Subject: Response To Application Number BE/74/19/PL at 218 Chichester Road North Bersted PO21 5BE

TO:	Arun District Council FAO: Finlay Gardner
FROM:	WSCC - Highways Authority
DATE:	6 December 2019
LOCATION:	218 Chichester Road North Bersted PO21 5BE
SUBJECT:	BE/74/19/PL Construction of entrance door & ramp on east elevation.
DATE OF SITE VISIT:	n/a
RECOMMENDATION:	Advice
S106 CONTRIBUTION TOTAL:	n/a

EXISTING &
PROPOSED
PLANS @ 1:100
218-222
CHICHESTER RD
N. BERSTED
2019.

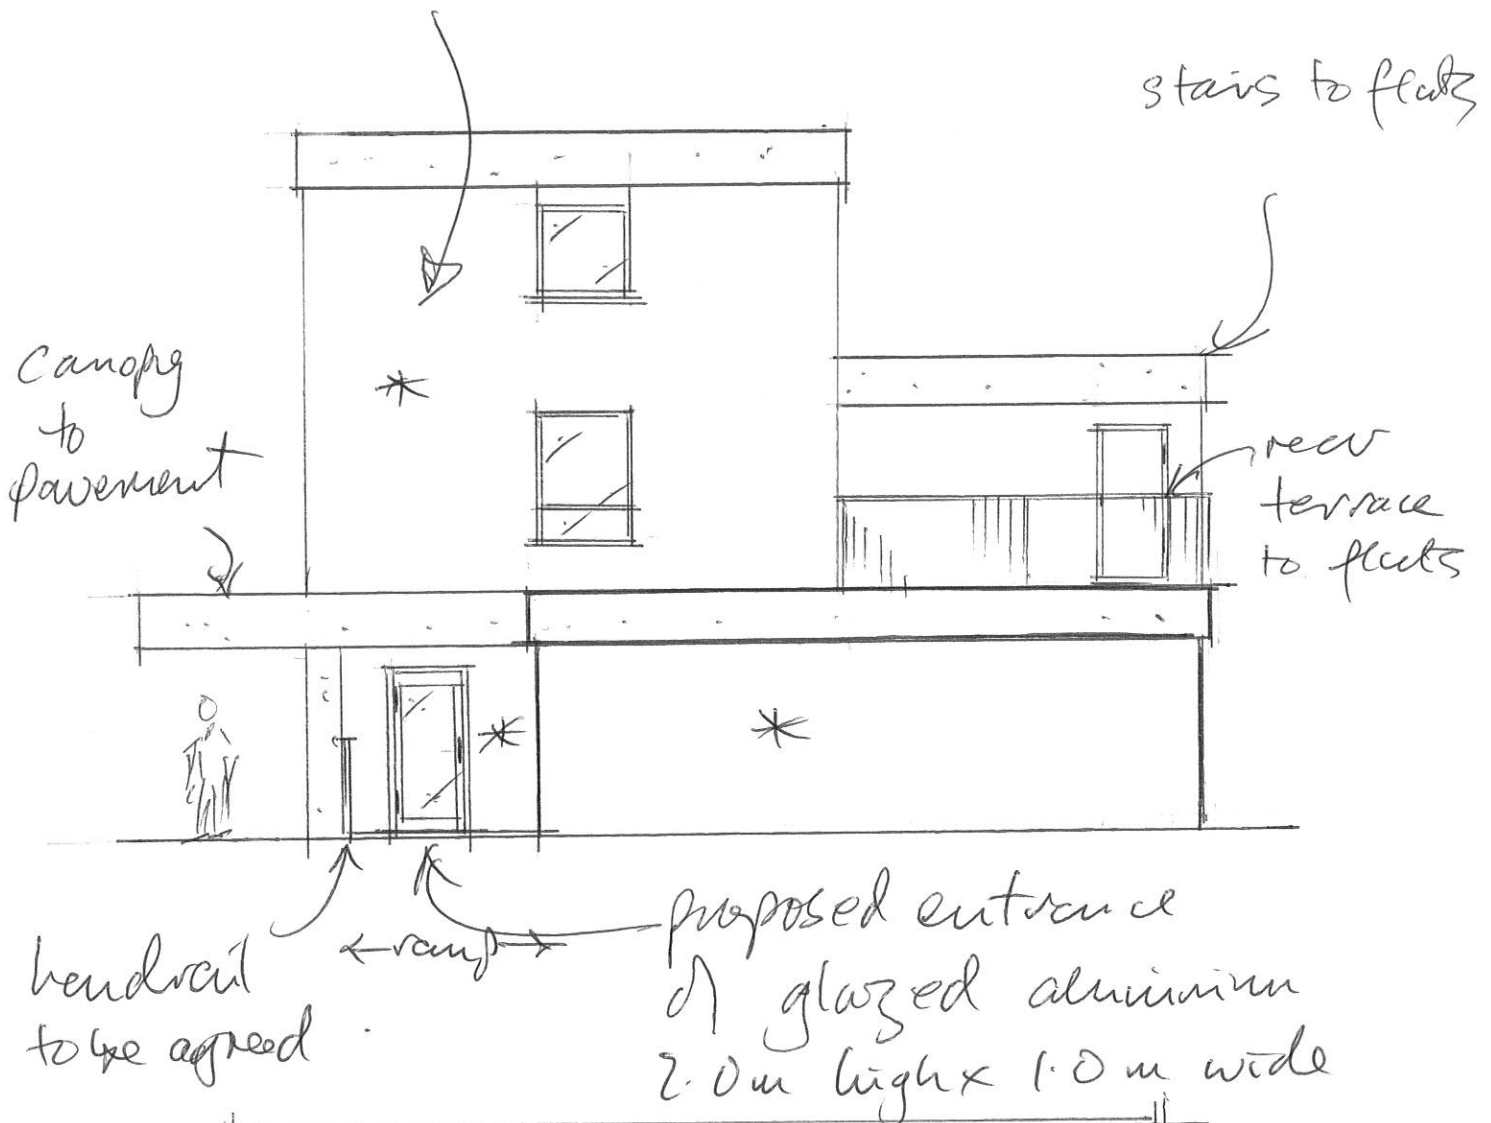
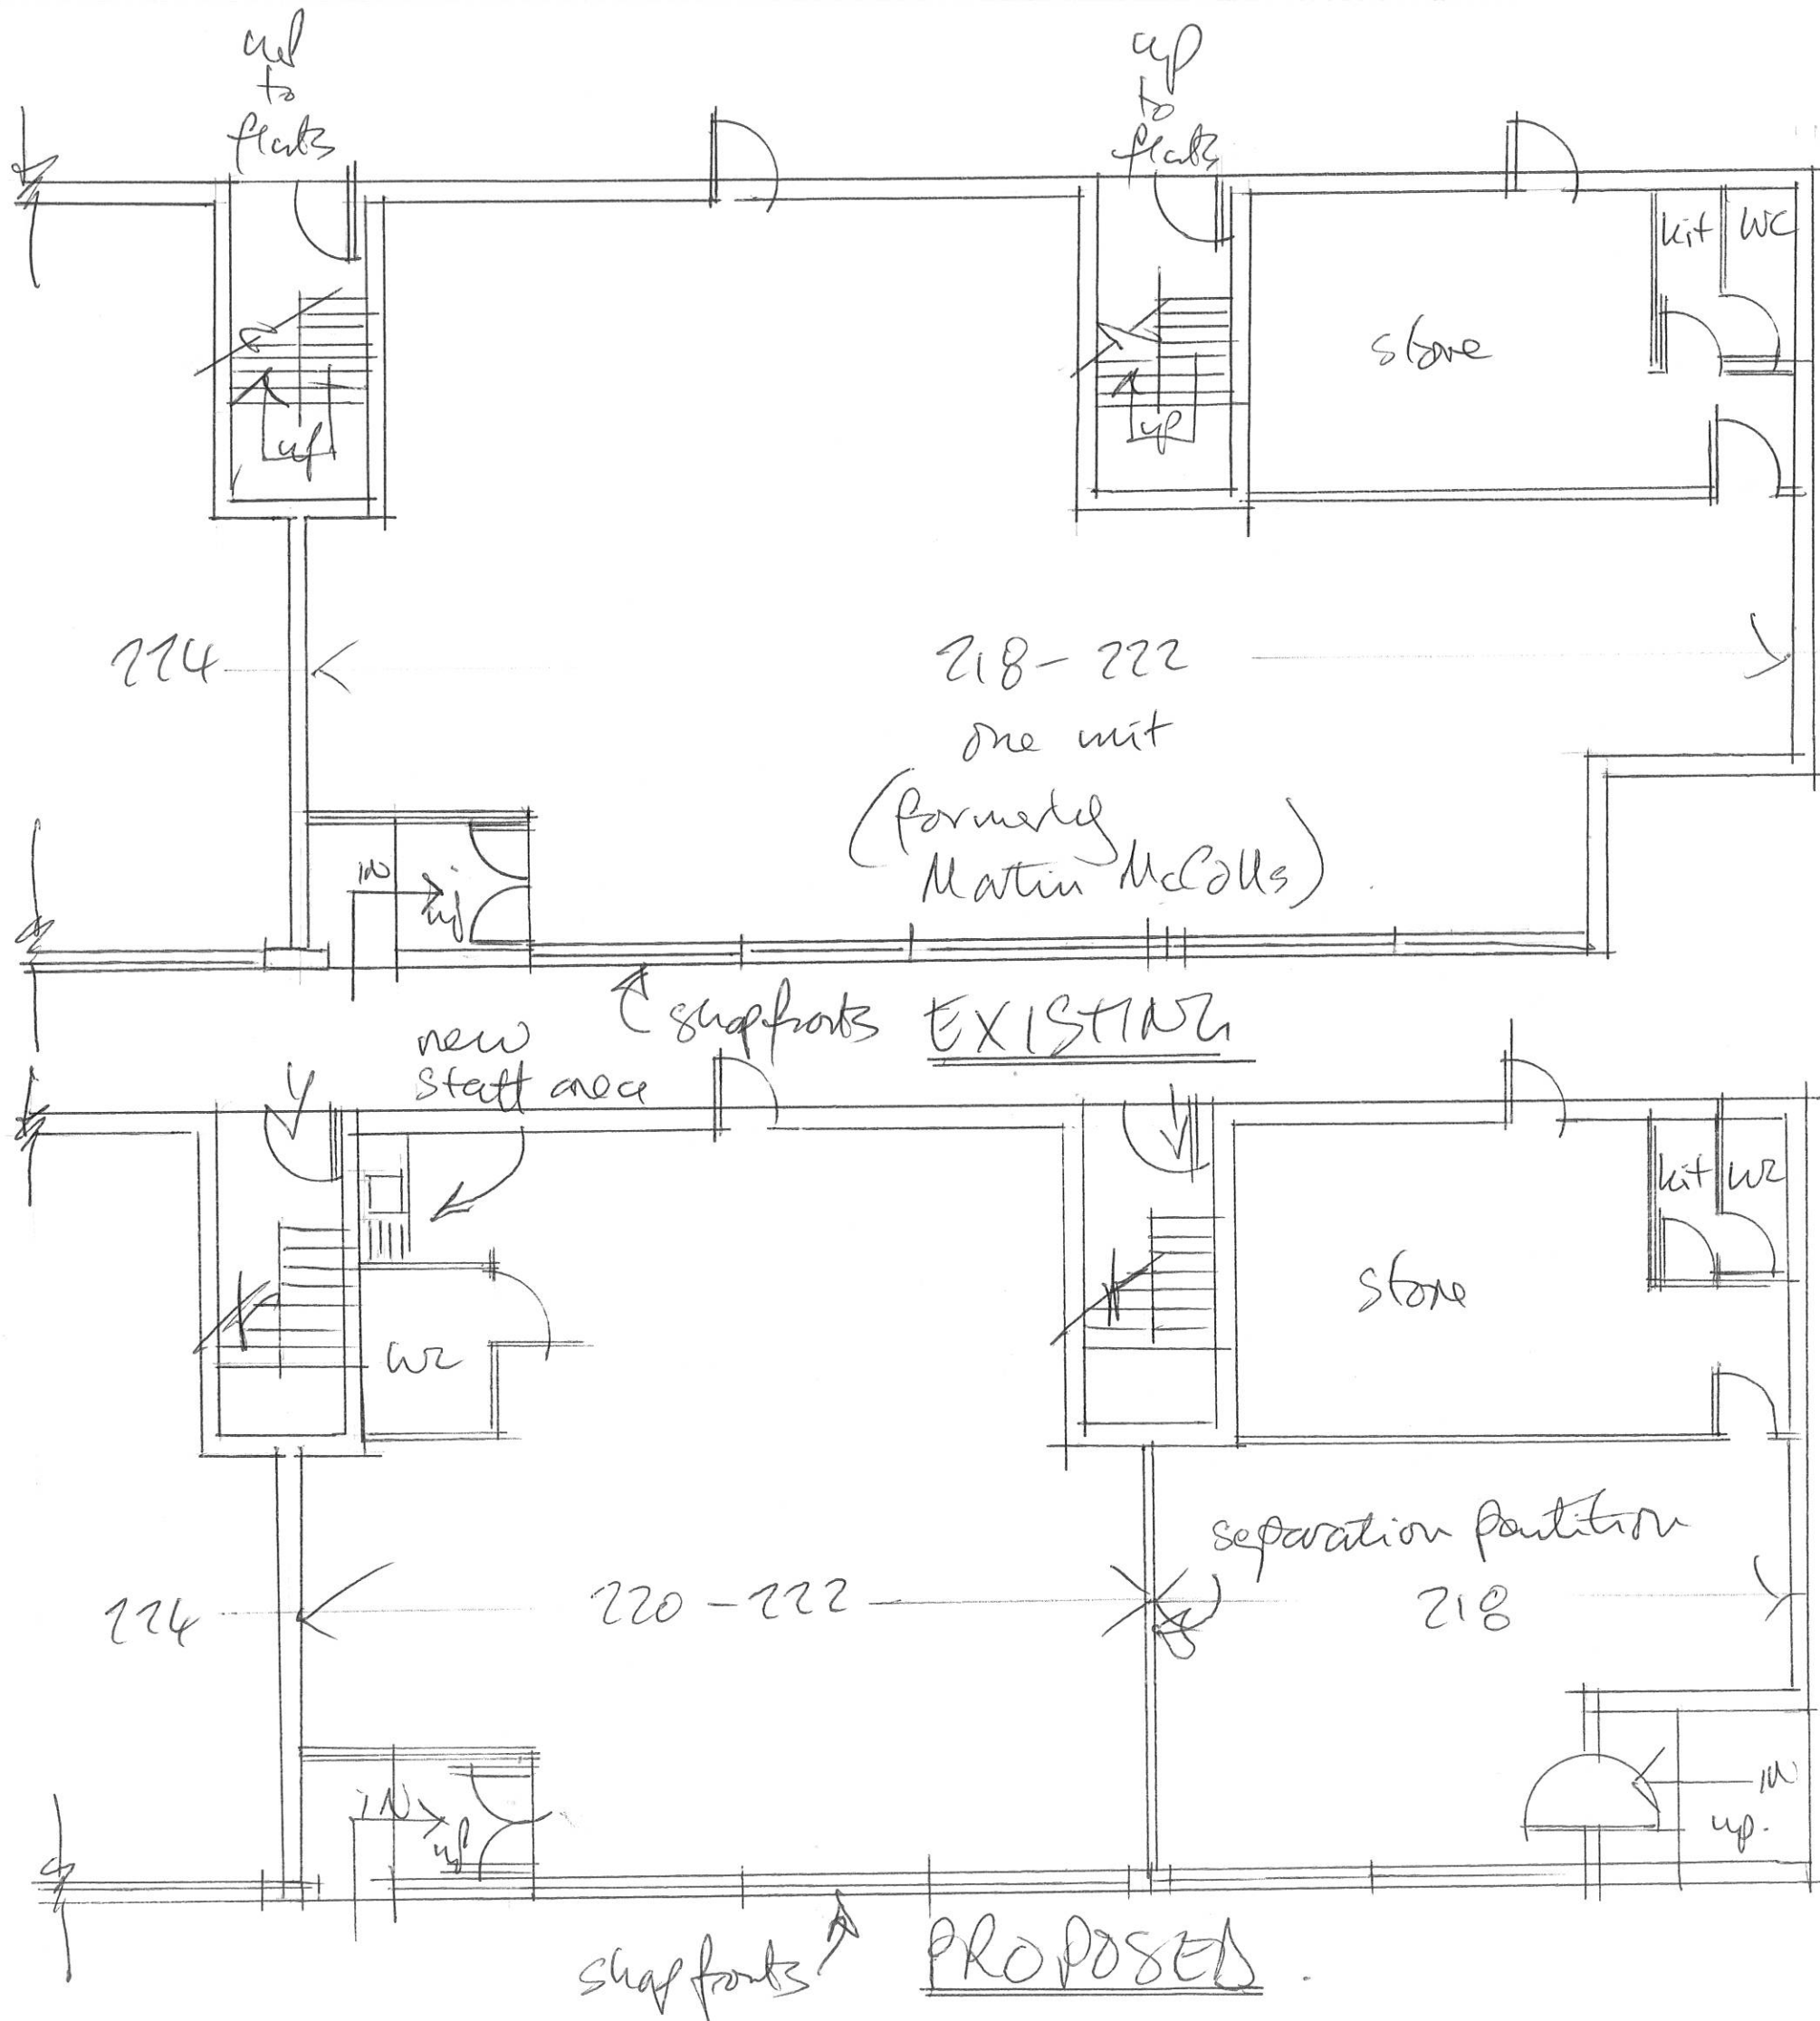
Upon inspection of the submitted plans and the comparison against WSCC local mapping and the Highway Boundary (HWB), the Local Highways Authority (LHA) observes that the proposal does not fall within, instead abuts the HWB. All this considering if the applicant proposes to increase the ramp in size, then we would request the Local Planning Authority (LPA) re-consults.
